**Date:** 31st May 2011  
**To:** Planning  
**Cc:** -  
**From:** Miriam Hill  
**Subject:** S6/2011/0833/FP – 1 The Cottages, Shepherds Way, Brookmans Park  
**Erection of part two storey, part single storey side extension**

I have reviewed the proposal for the above site and refer to drawing number 2101/2.

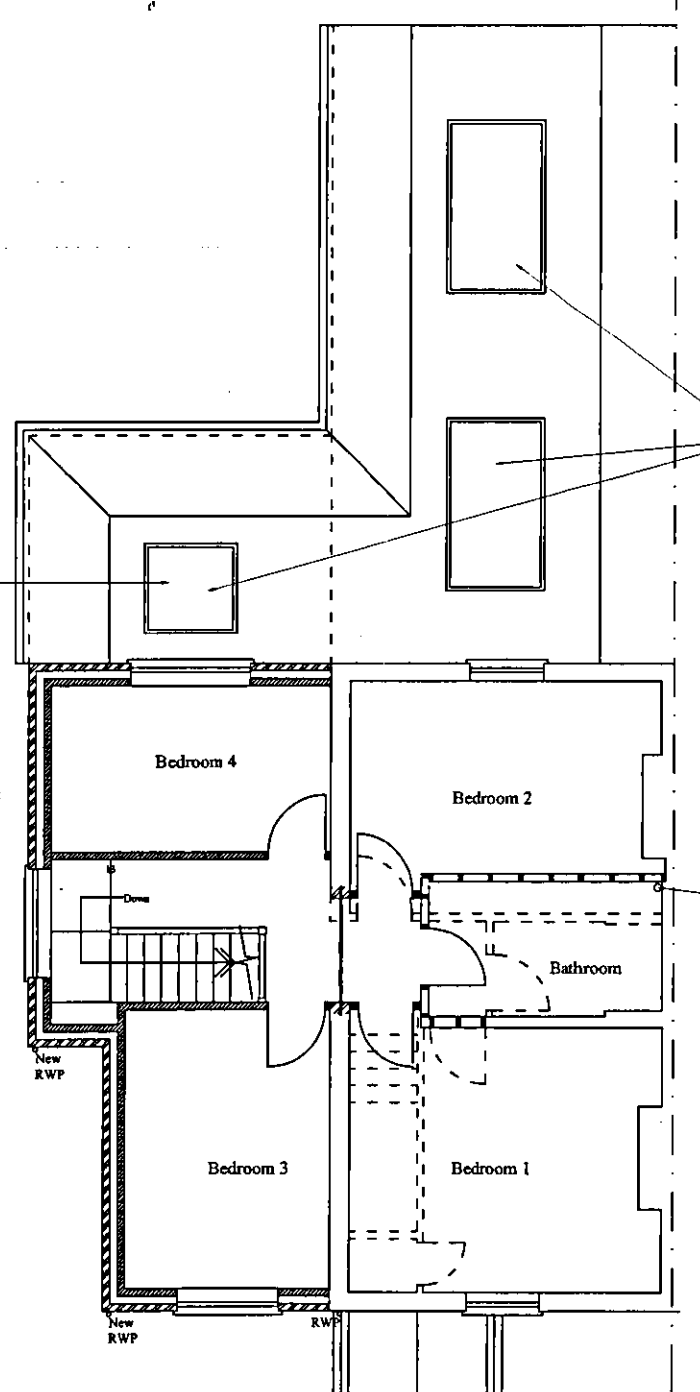
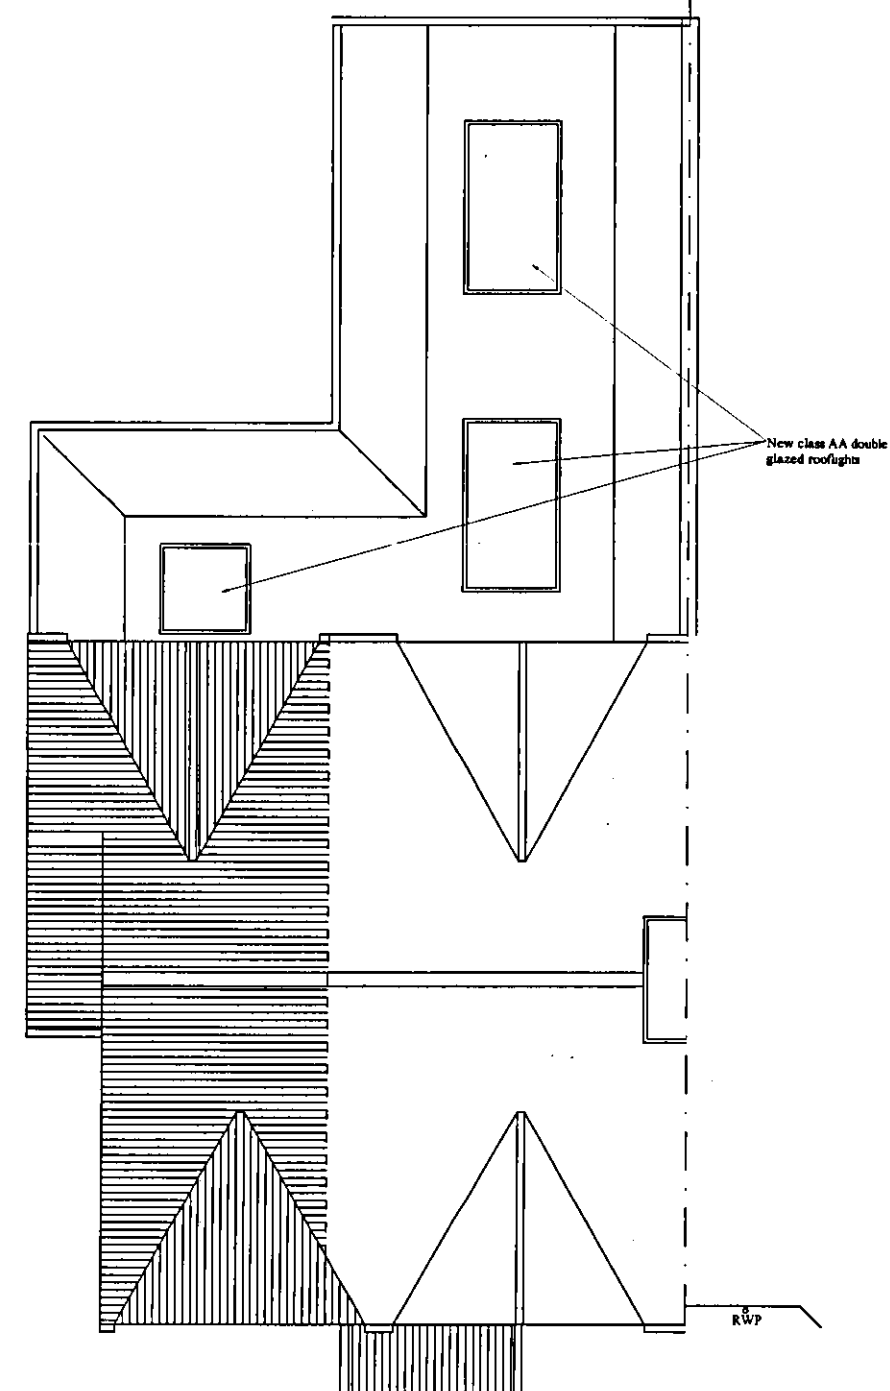
**Arboriculturally:** There is a very large ash tree within the rear garden of the above property. It is a sufficiently large to be effected by the proposed extension. Before any thought is given to Arboricultural Method Statements etc it is a necessity that the tree be inspected by tree surgeon as it appears to be in a very poor state. This should be done in the near future, irrespective of the planning application. If this tree is removed there will be no trees on site to be effected by the proposal.

**Landscape:** The proposal will bring the end of the house much closer to the boundary and road. Little can be done to screen the extension as there is no verge, garden etc to plant in.
